**FINAL DRAINAGE REPORT  
FOR  
LATIGO TRAILS FILING NO. 9  
AND  
ADDENDUM TO MASTER DEVELOPMENT/  
PRELIMINARY DRAINAGE PLAN  
FOR LATIGO TRAILS,  
EL PASO COUNTY, COLORADO**

June 2022

PCD File No.: SF2136

BUFFALO RIVER TRAIL PROFILE
STA 34+00.00 TO 38+00.00

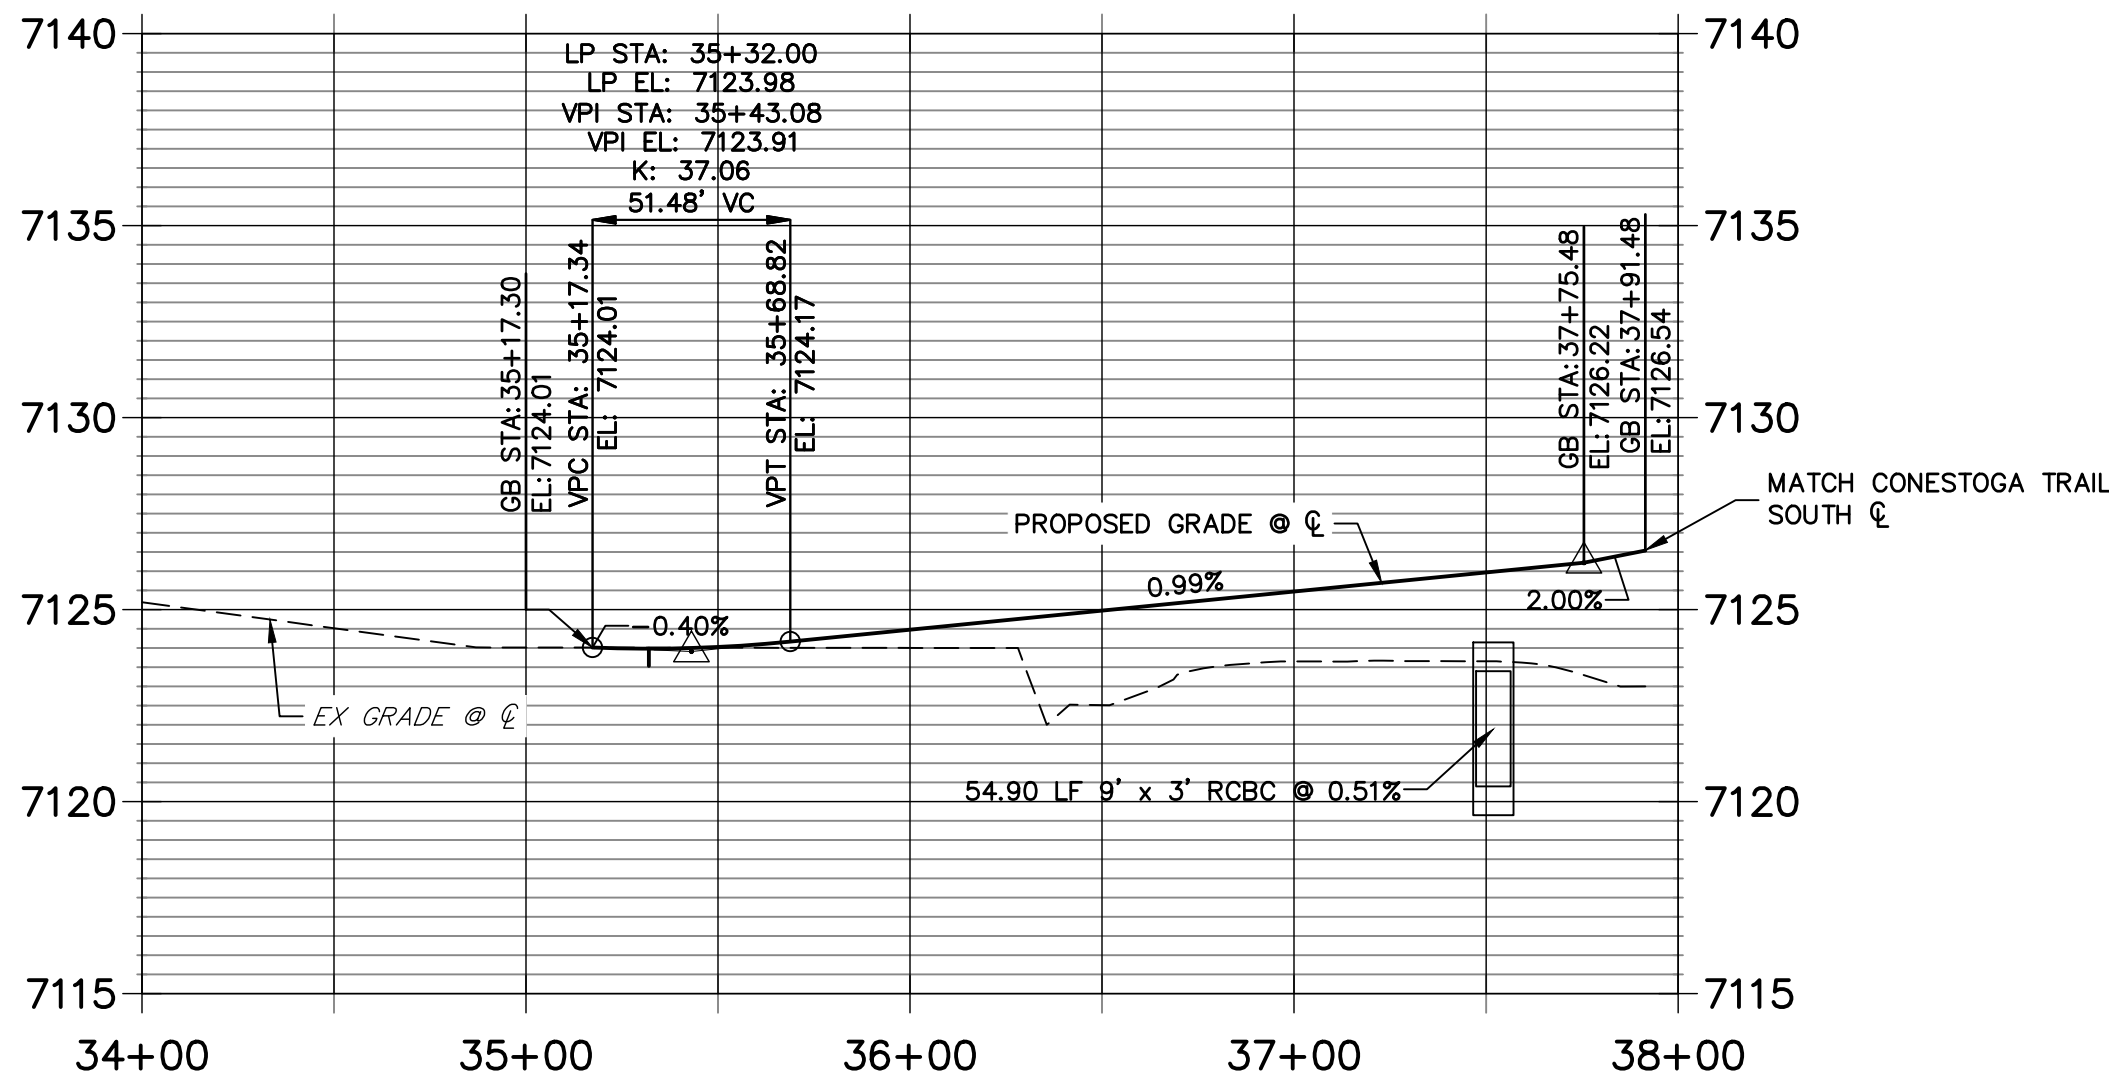
Revise statement. The maximum of 6" over-topping is measured at the shoulder, not the centerline.

JR Response: Revised wording to indicate our design will not over-top the roadway.
